Application for a non-material amendment following a grant of planning permission.

Side extension over garage, single storey rear extension and front porch.

Reference number: R/50/20/HH

New ground floor front window re-positioned centrally.  
Amendment to width of porch

DRWG TITLE: **Proposed Elevations**
 DRWG No: **1034_301**
 REV: **C**

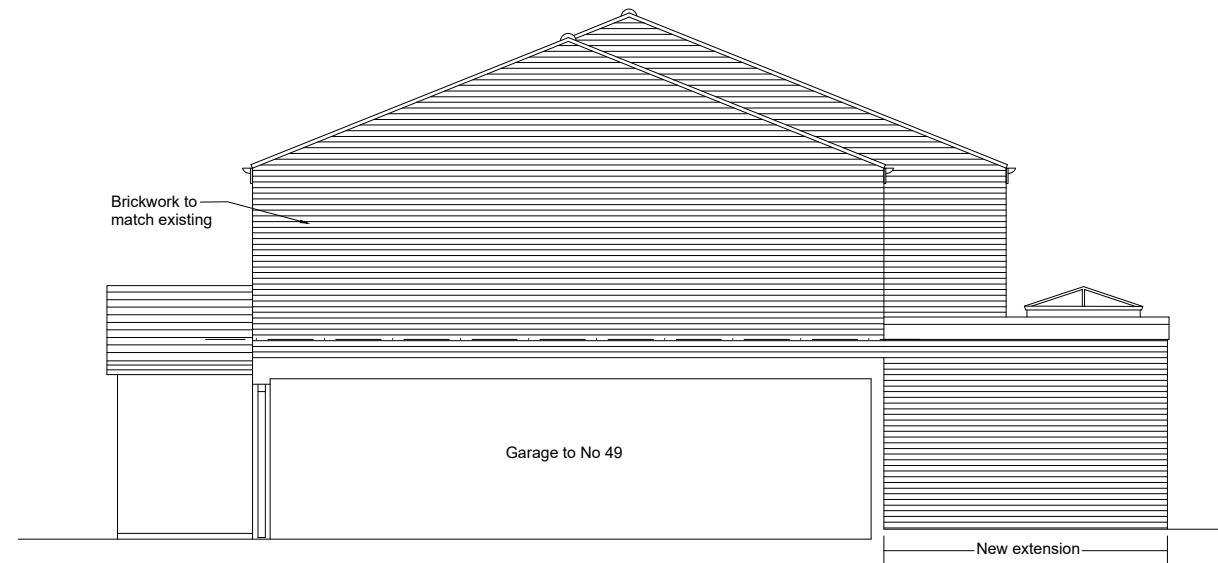
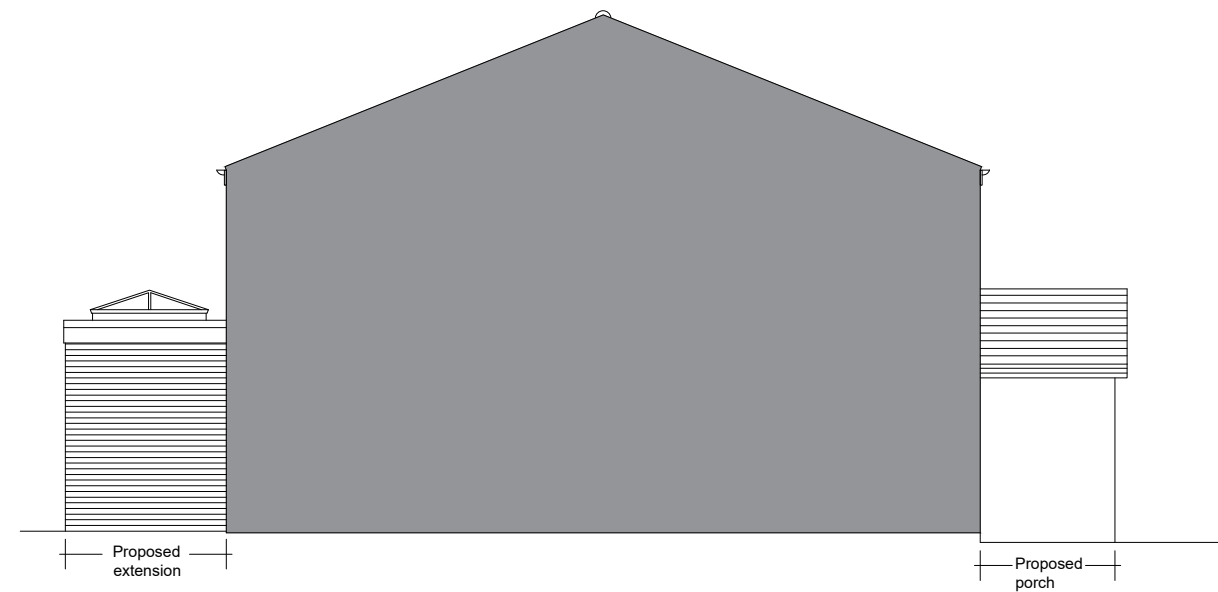
All other windows being centralised.  
More storage space required in porch.

1034\_201\_B - Proposed Plan  
1034\_301\_C - Proposed Elevations
